RE: APD SE Area Command Center Project – Narrative

DRB Project Number: 1003450 Hearing Date: Feb 3, 2016  
 Project: 800 Louisiana Agenda Item No: (1)

**Subject:** Project # 1003450, Case # 15EPC-40029 – APD SE Area Command

C4 DETAIL
S #4

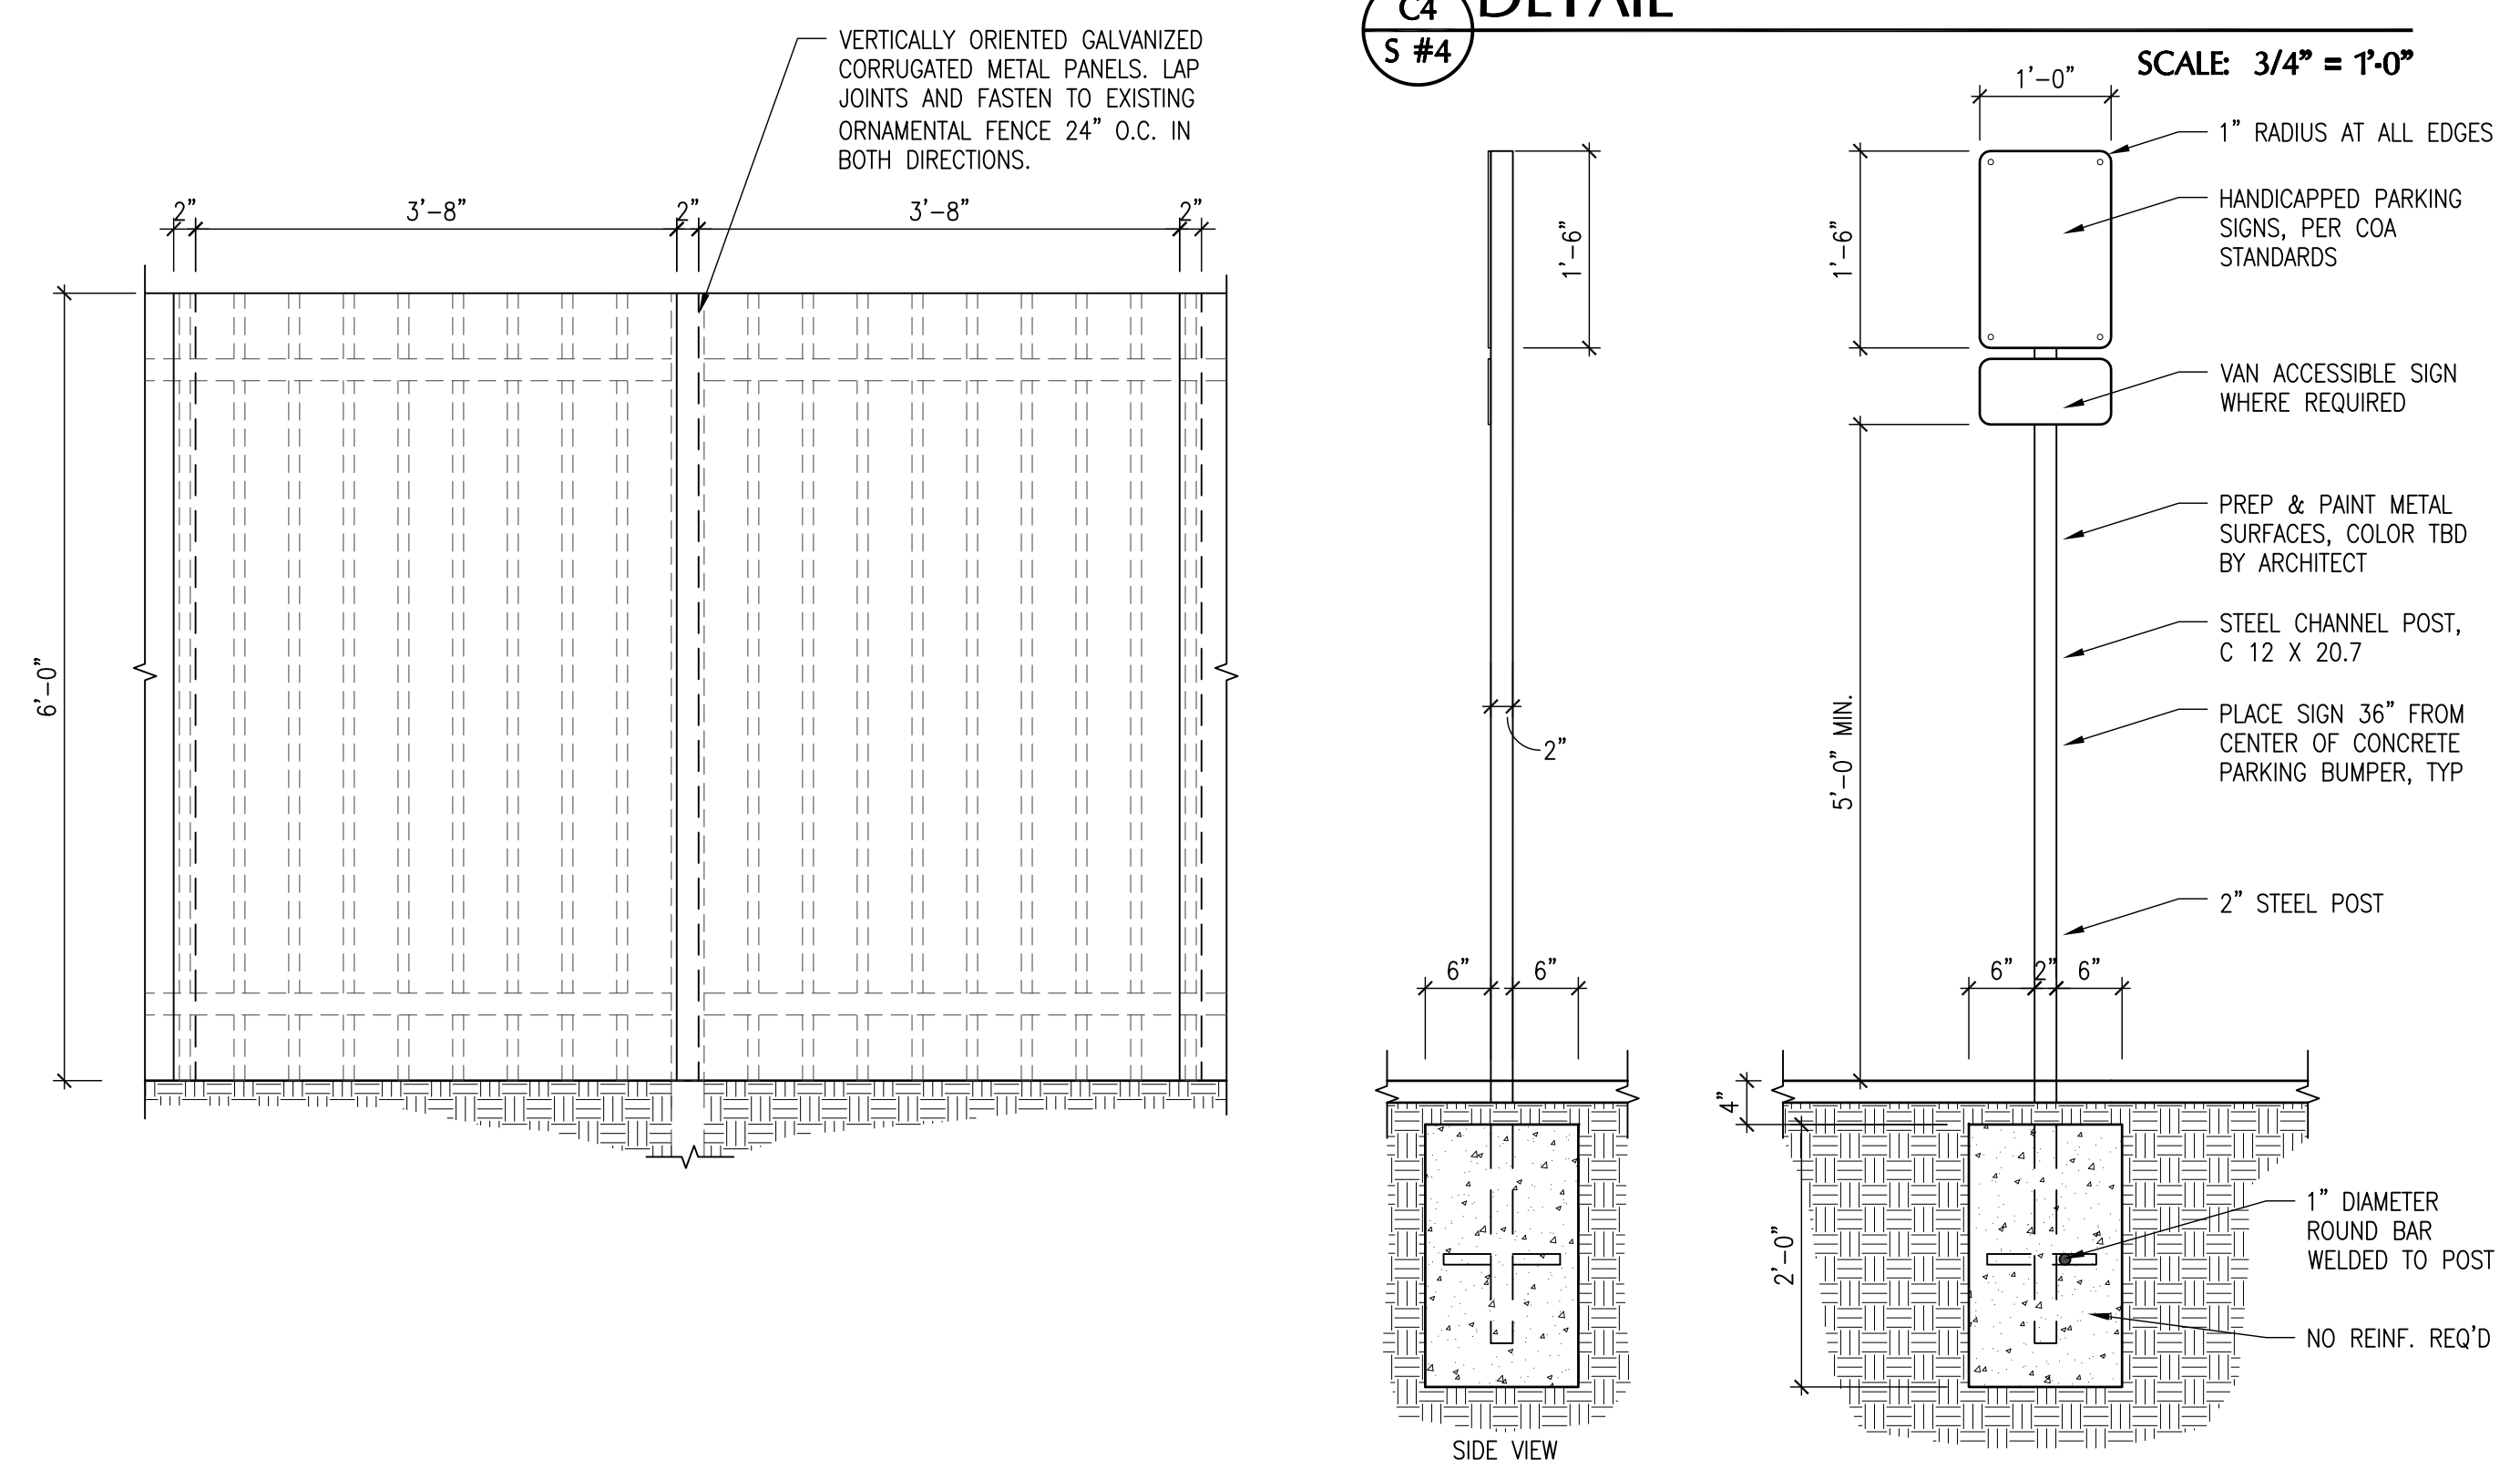
2. The ADA accessible parking sign must have the required language per 66-7-352.4C NMSA 1978 **"Violators Are Subject to a Fine and/or Towing."** Please show detail of ADA signs. **The required language is met and the details are shown on Sheet #4.**

A1 ADA ACCESSIBLE RAMP DETAILS
S #4

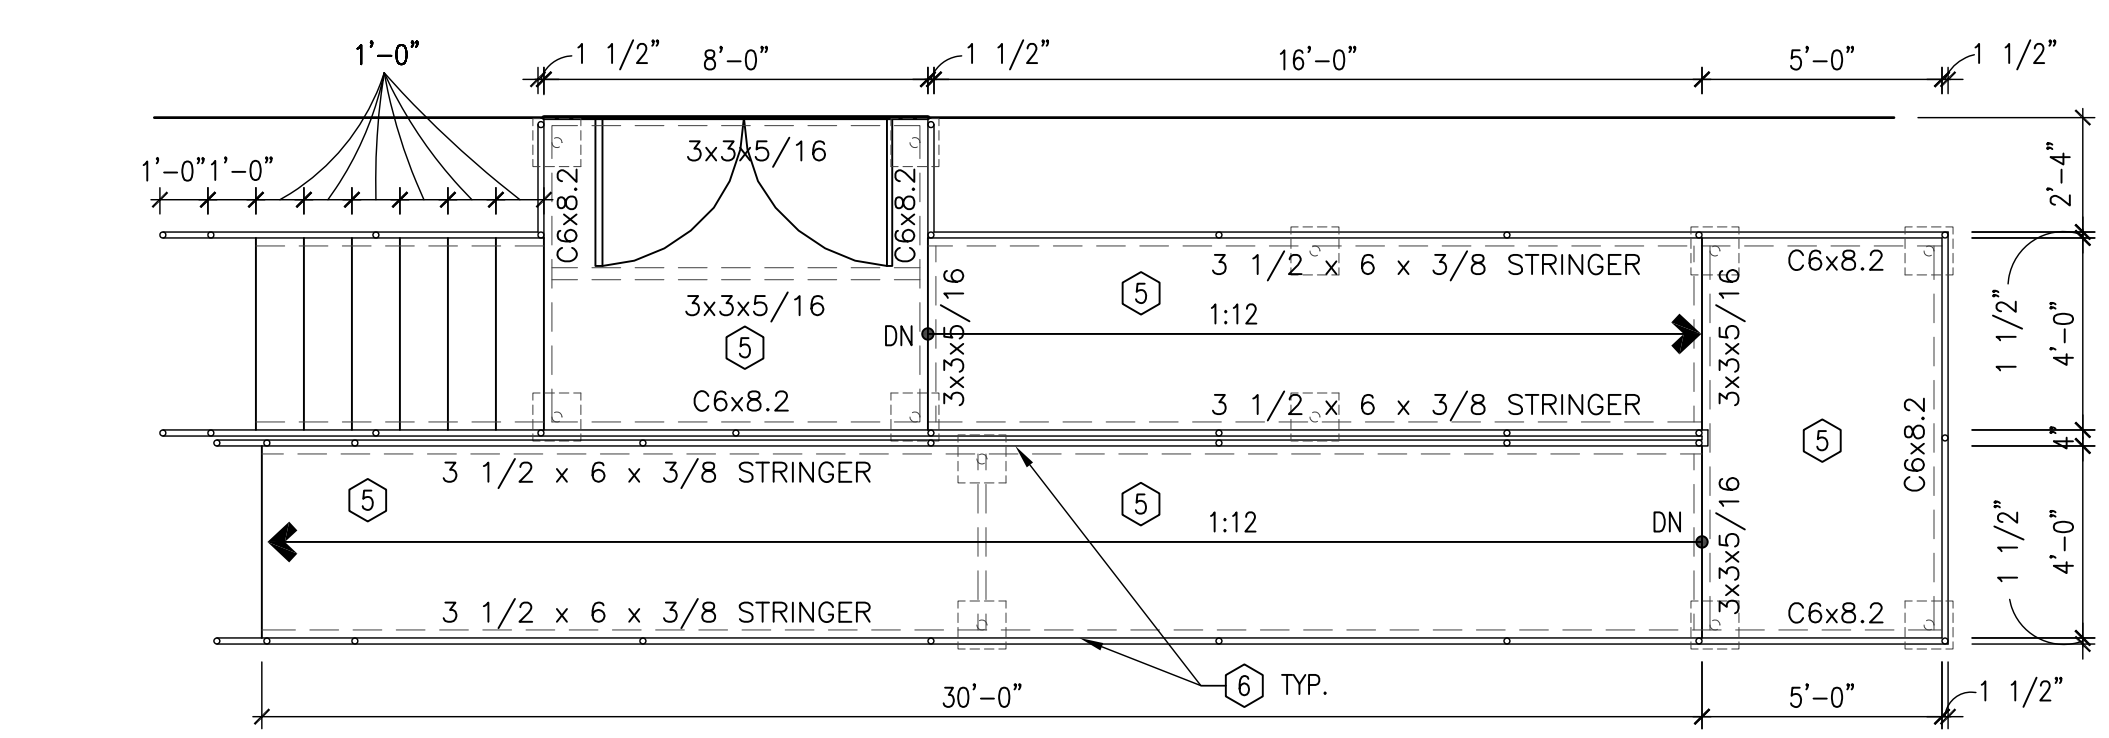
4. Please detail ADA ramps from public right-of-way and proposed ADA ramps into modular building. **ADA ramps are called out on Sheet #1 and details are shown on Sheet #4.**
